**Your Ref: 2026/0480
Our Ref: B/01838**

66 Longley Street, Barugh Green, Barnsley, S75 1NT - (BARNs) - Erection of a detached bungalow and associated works including subdivision of residential garden and alterations to parking arrangements (Custom/Self-Build)

Yorkshire Water objects to the application due to lack of submitted proposed drainage details.

A	EXISTING AND PROPOSED SEWERS SHOWN ON PLAN. ROOF HATCH UPDATED FOR PROPOSED PLOT.	29.07.26
REV	DESCRIPTION	DATE
DEVELOPMENT		
LAND ADJACENT TO 66 LONGLEY STREET, BARUGH GREEN		
DRAWING TITLE		
PROPOSED SITE LAYOUT		
DATE	25.04.26	SCALE 1:250@A3
DRAWN	WS	
DRAWING REF	LS-NB-PSL-01	REV A

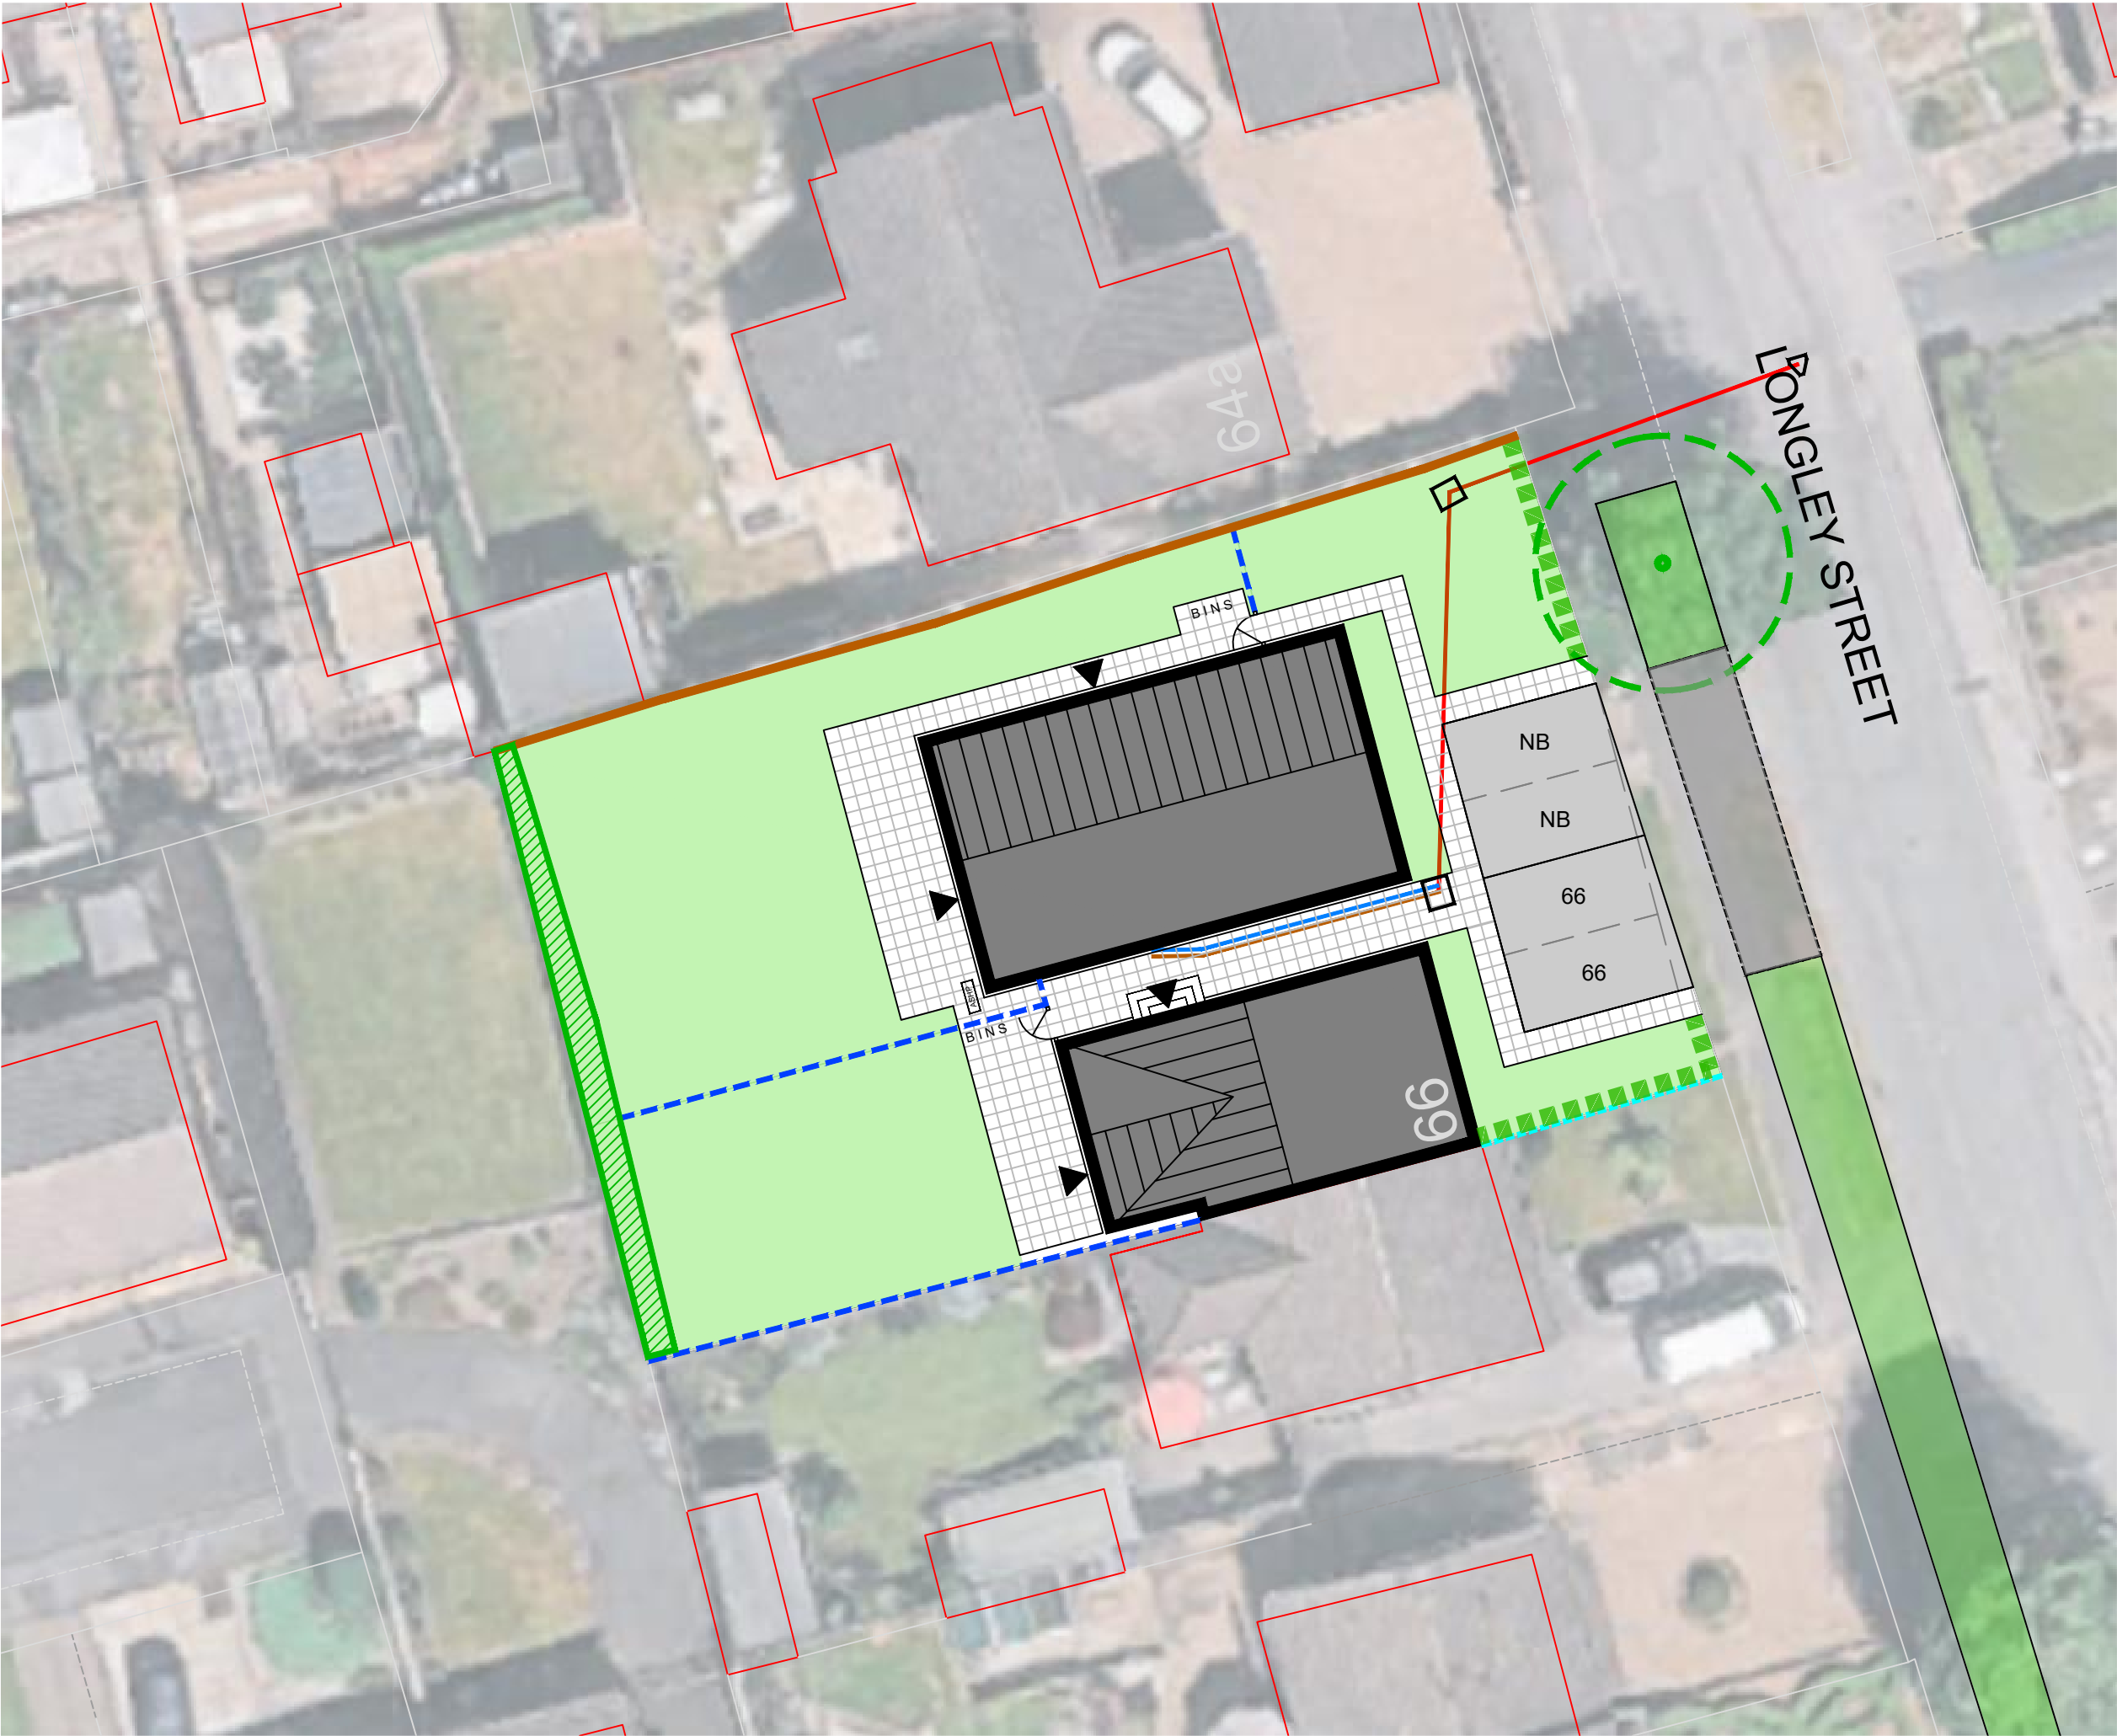
Development of the site should take place with separate systems for foul and surface water drainage. The separate systems should extend to the points of discharge to be agreed.

The developer is proposing to discharge surface water to public sewer however, sustainable development requires appropriate surface water disposal.

Yorkshire Water promote the surface water disposal hierarchy, and the developer must provide evidence to demonstrate that surface water disposal via infiltration or watercourse are not reasonably practical before considering disposal to public sewer.

As the proposal site is currently undeveloped, no positive surface water is known to have previously discharged to the public sewer network. Surface water discharge to the existing public sewer network must only be as a last resort and the developer is required to eliminate other means of surface water disposal.

As a last resort, and upon receipt of satisfactory evidence to confirm the reasons for rejection of other methods of surface water disposal, curtilage surface water may discharge to public sewer at a restricted rate not to exceed 3.5 litres per second.
